WISWELL PARISH COUNCIL

Planning Application No: 3/2011/0403

**New agricultural store to replace existing sheds with 4kWp photovoltaic array on the south facing roof pitch
2 Whiteacre Lane, Barrow, Clitheroe, Lancashire, BB7 9BJ**

PH/SW/200
MAY 2011.

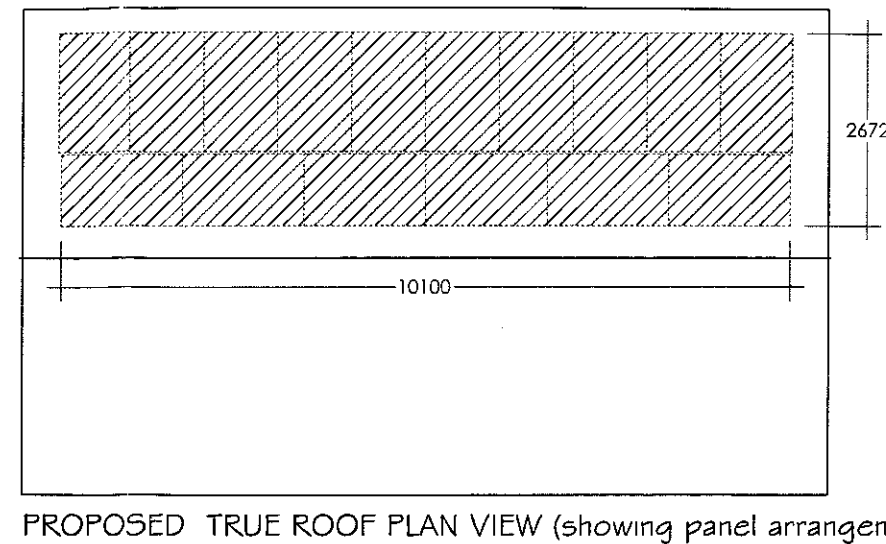
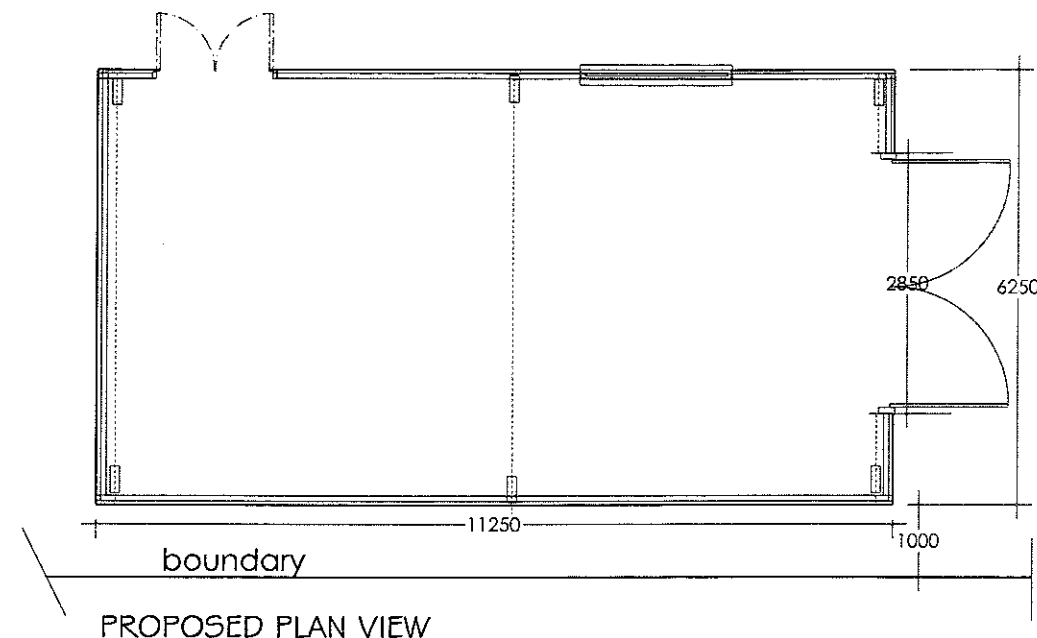
1. The sighting of the store is directly behind a neighbouring property and appears to be visually obtrusive to nearby residents.
2. The Councillors understand that an electronics business is currently run from the address. Is the new store intended to be used as part of this business in the future?
3. The new store represents a large increase in area from the previous store (66 sq metres from 24 sq metres). It appears to be far larger than is necessary for implements and livestock on a one acre field.
4. The sighting of the store directly behind a neighbouring property could have a detrimental environmental effect on nearby residents.
5. The Councillors would like to query the regulations for keeping livestock in such an environment, surrounded by residential properties.
6. Other factors may need to be taken into consideration relating to the grazing of cows, as follows:
